DECISION DELEGATED TO HEAD OF PLANNING**DECISION DELEGATED TO HEAD OF PLANNING**

Application No: H03-0880-23 **Applicant:** Mr & Mrs Broderick
Proposal: Erection of single storey extension to dwelling
Location: 40 Haywain Drive Deeping St Nicholas Spalding
Terminal Date: 27th November 2023

This is an application for a Lawful Development Certificate to confirm that the proposed single storey rear extension at 40 Haywain Drive, Deeping St Nicholas is lawful and does not require the submission of a planning application.

Proposed Plan

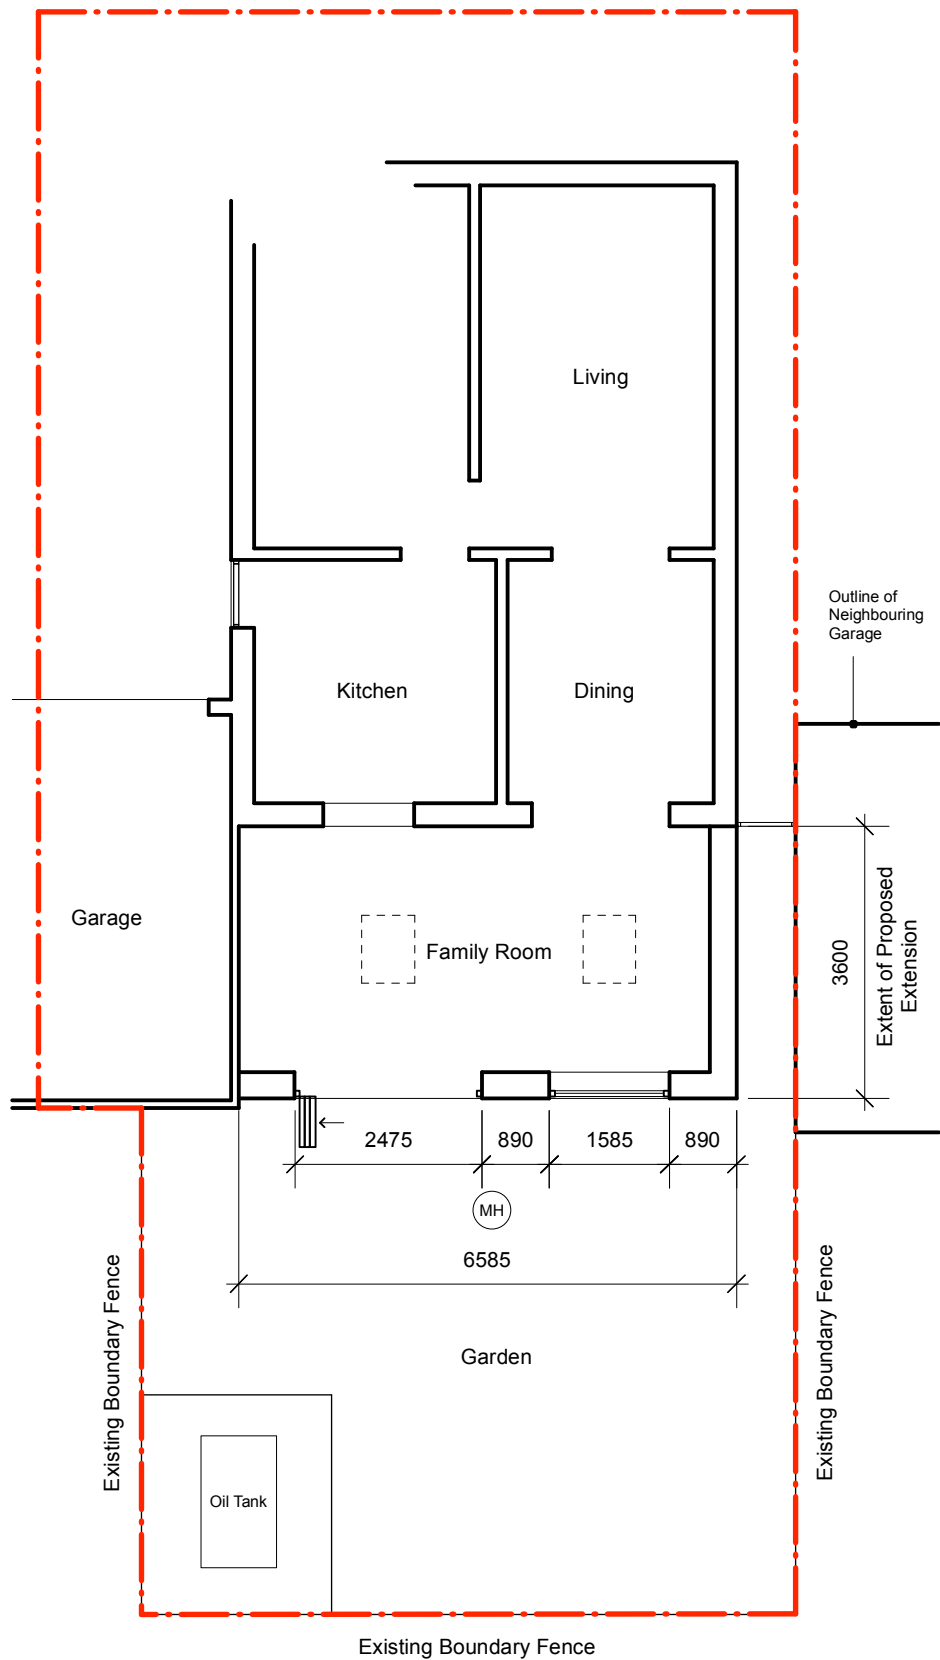
The application states that the extension is single storey and sits to the rear of the dwelling; however, in considering and assessing the plans, the proposed extension appears to be connecting to the existing garage, which is attached to the side of the existing dwelling, and extends/projects beyond both the rear elevation of the host dwelling and the side elevation of the dwelling, when considering the garage in addition.

As the proposed extension is connecting to the garage's side elevation, which itself projects beyond the side elevation of the host dwelling, the extension would be a side extension in addition to solely a rear extension. Therefore, as the proposed extension would comprise a width greater than half the width of the original dwellinghouse when viewed in its totality, it would not constitute permitted development under Part 1 Class A.

The proposed extension does not constitute permitted development under Schedule 2 Part 1 Class A of the General Permitted Development Order (2015). The proposed width of the extension would be greater than half the width of the original dwellinghouse and would constitute operational development for which a grant of planning permission would be required.
